EPC STORMWATER REVIEW COMMENTS
 IN ORANGE BOXES WITH BLACK TEXT

EL PASO COUNTY GRADING AND EROSION CONTROL PLAN CHECKLIST

EPC Project Number: **PPR255**

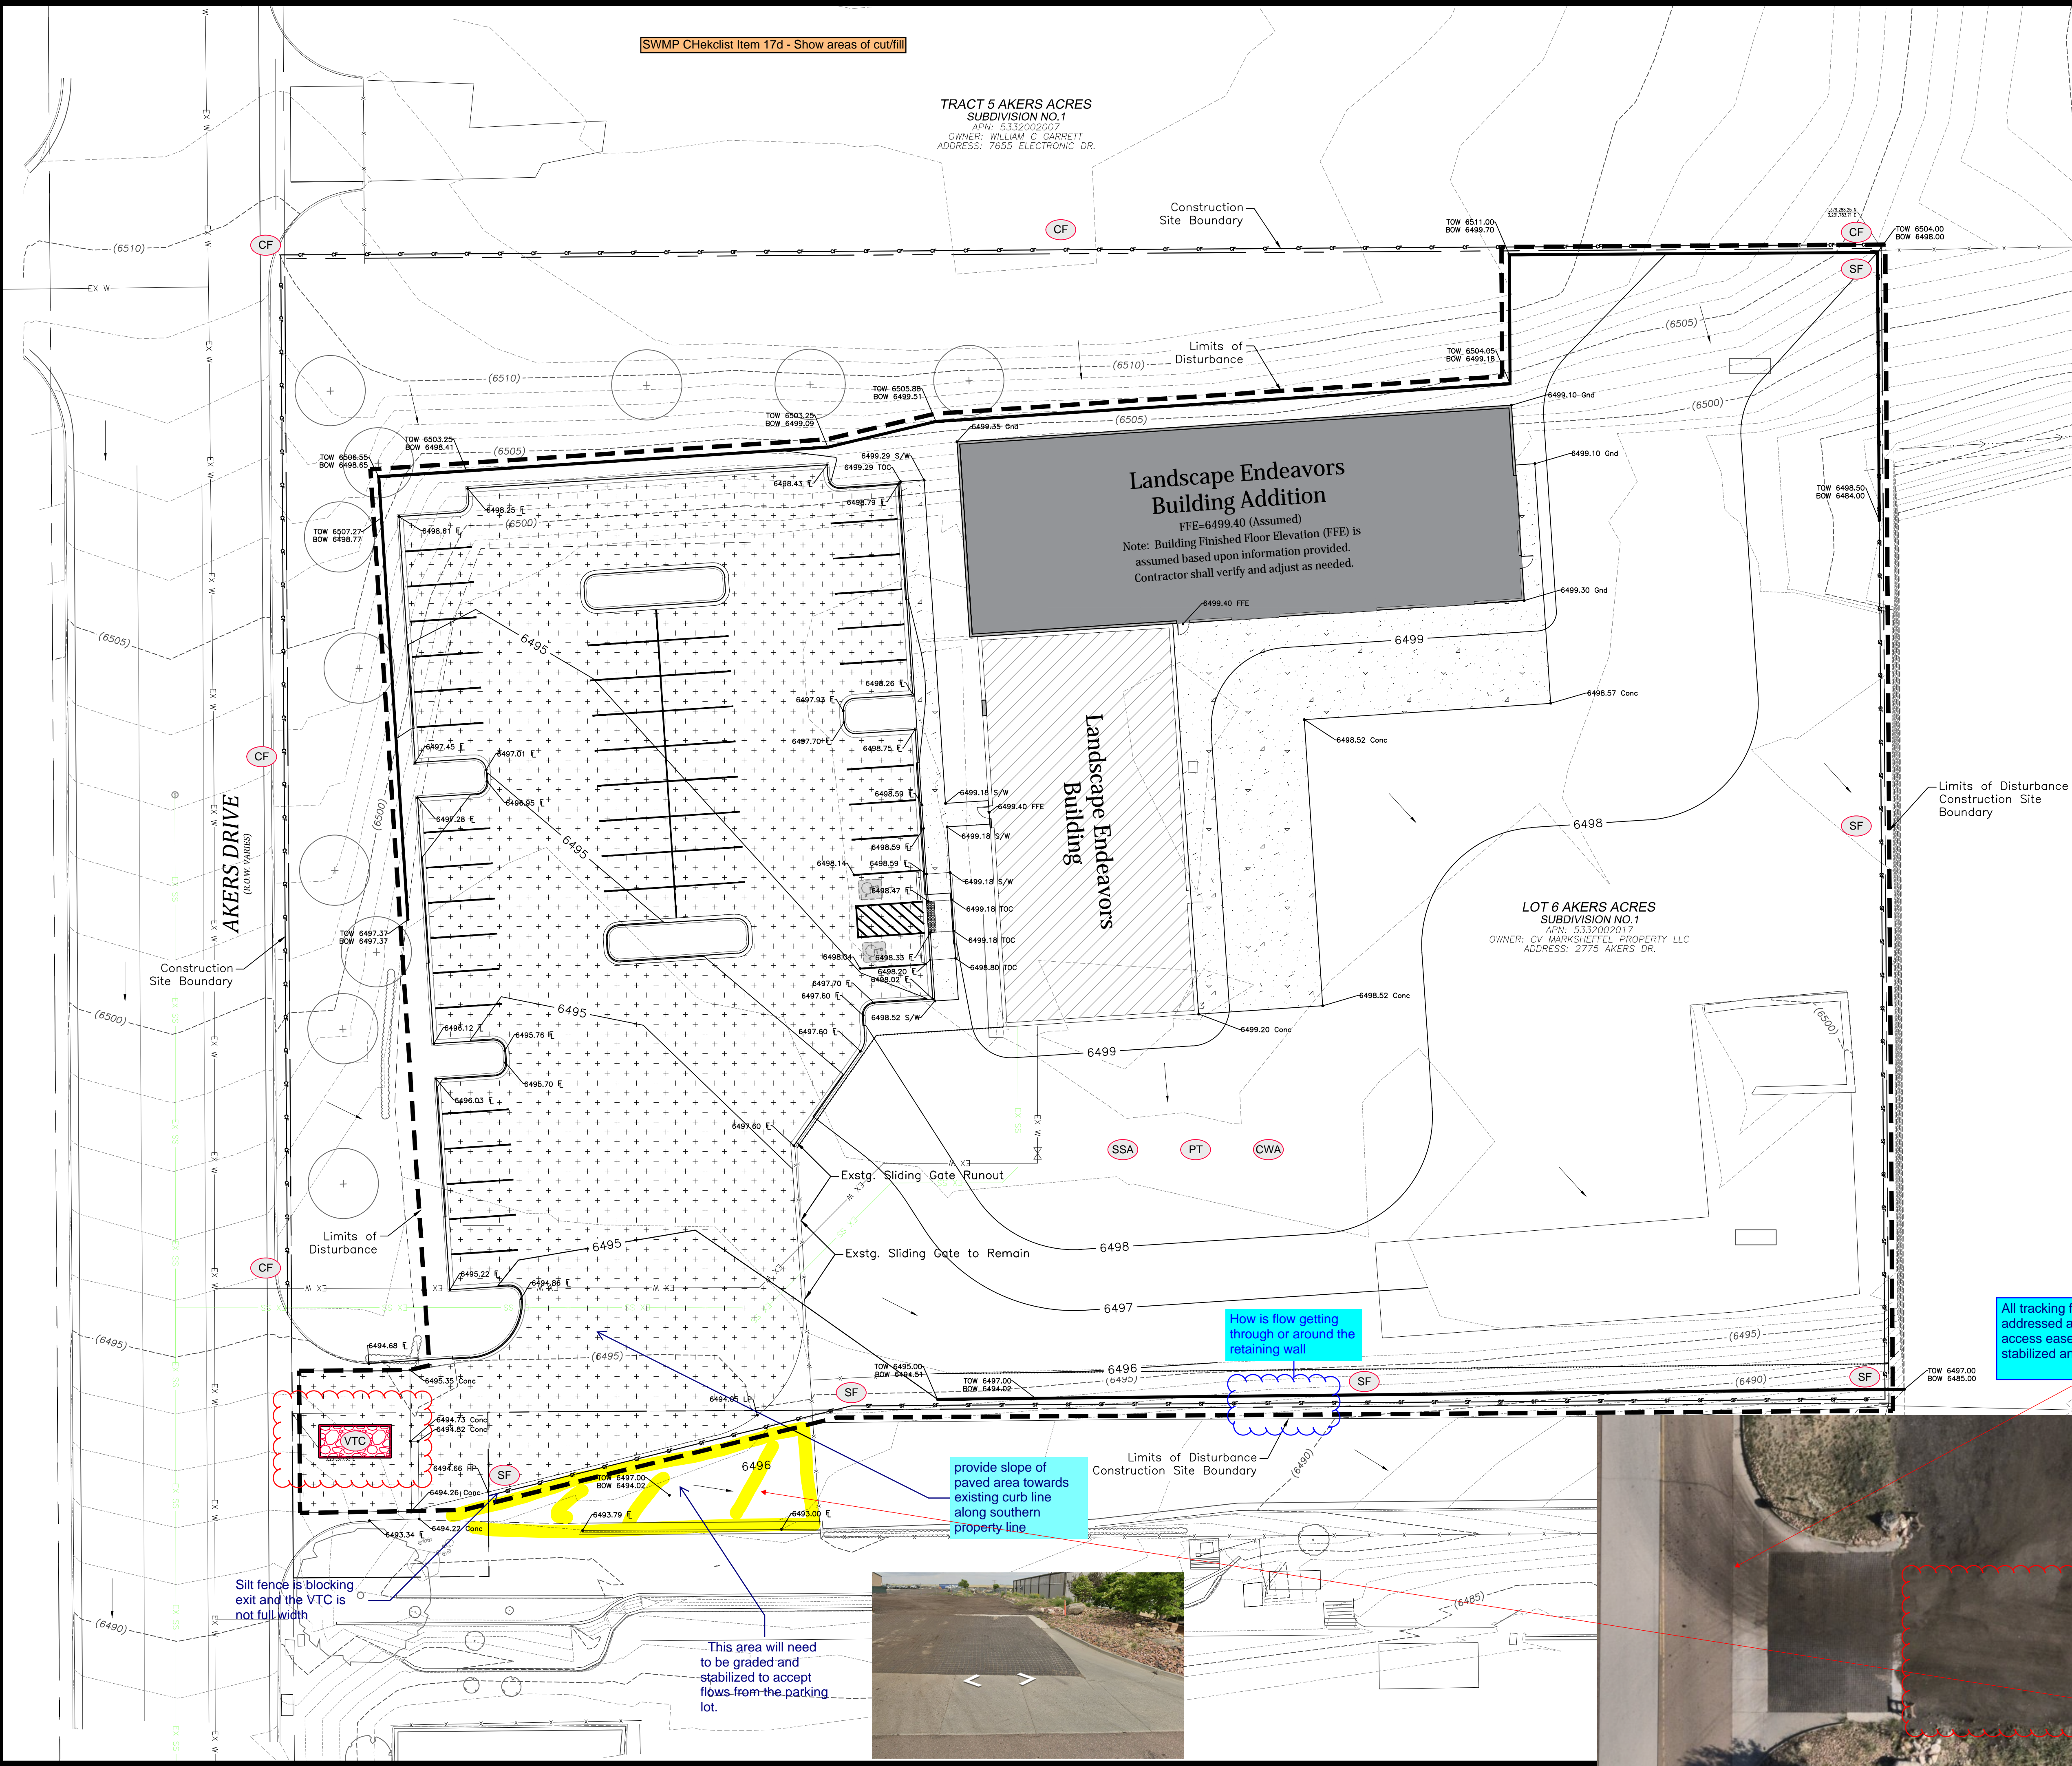
v	All proposed temporary construction control measures, structural and non-structural. Temporary construction control measures shall be identified by phase of implementation to include "initial," "interim," and "final" or shown on separate phased maps identifying each phase		N
w	Vehicle tracking provided at all construction entrances/exits. Construction fencing, barricades, and/or signage provided at access points not to be used for construction		Y
x	Temporary sediment ponds provided for disturbed drainage areas greater than 1 acre		N
